**Maxwell Underground Coal Mine (SSD 9526) RTS Comment**

I refer to the Response to Submissions (RTS) submitted by Malabar Coal ("the Proponent") in relation to the Maxwell Underground Coal Mine Project (SSD9526). I make the following comment on the RTS on behalf of Muswellbrook Shire Council. Council appreciates the opportunity for comment.

Plate 3-1 – Existing Site Access Road from Thomas Mitchell Drive

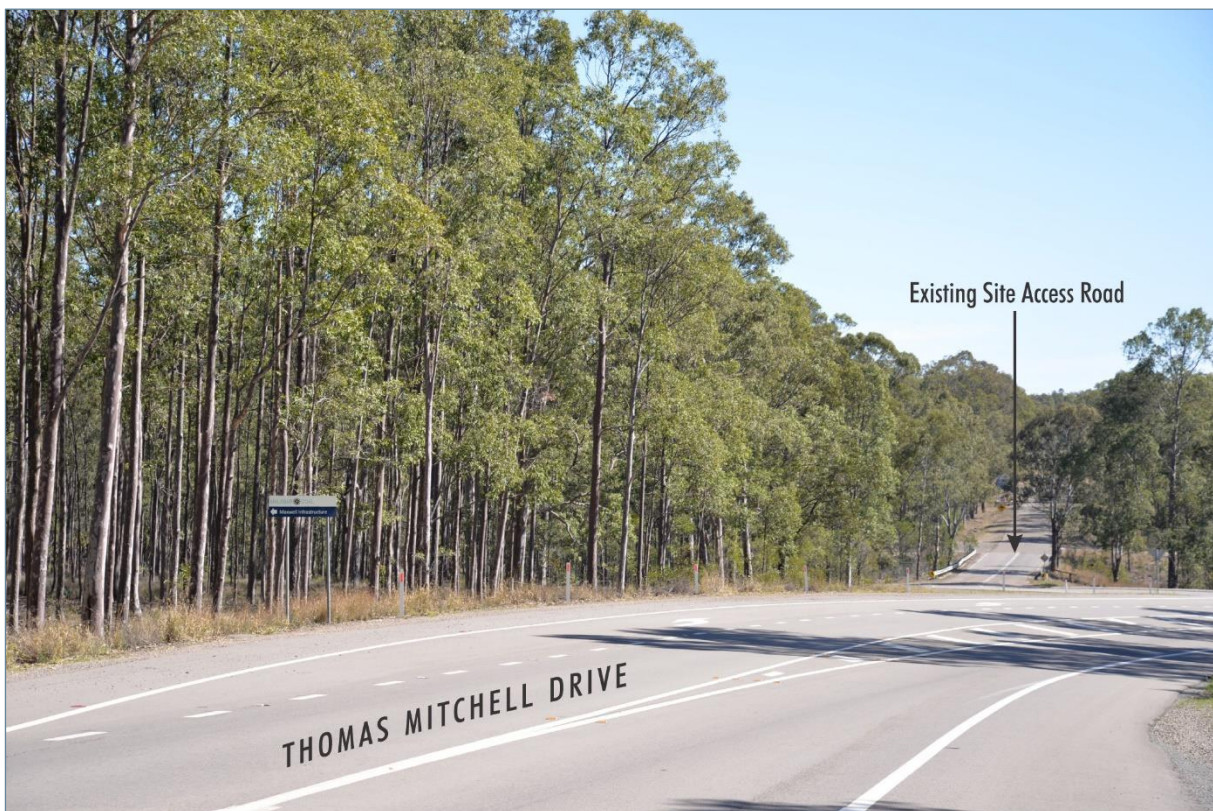
7.0 Issues with the site access road from Thomas Mitchell Drive to the Mine Entry Area in the first year of mining operations.

Council accepts that to balance earthworks volumes and material placement, the MEA and the site access road need to be constructed simultaneously. Council is still concerned about the transport of coal prior to the road being sealed.

To balance earthworks volumes and material placement the MEA and the site access road need to be constructed simultaneously. The site access road would be sealed during the first year of mining operations. During this first year only relatively small quantities of coal would be transported (less than 500 kilotonnes).
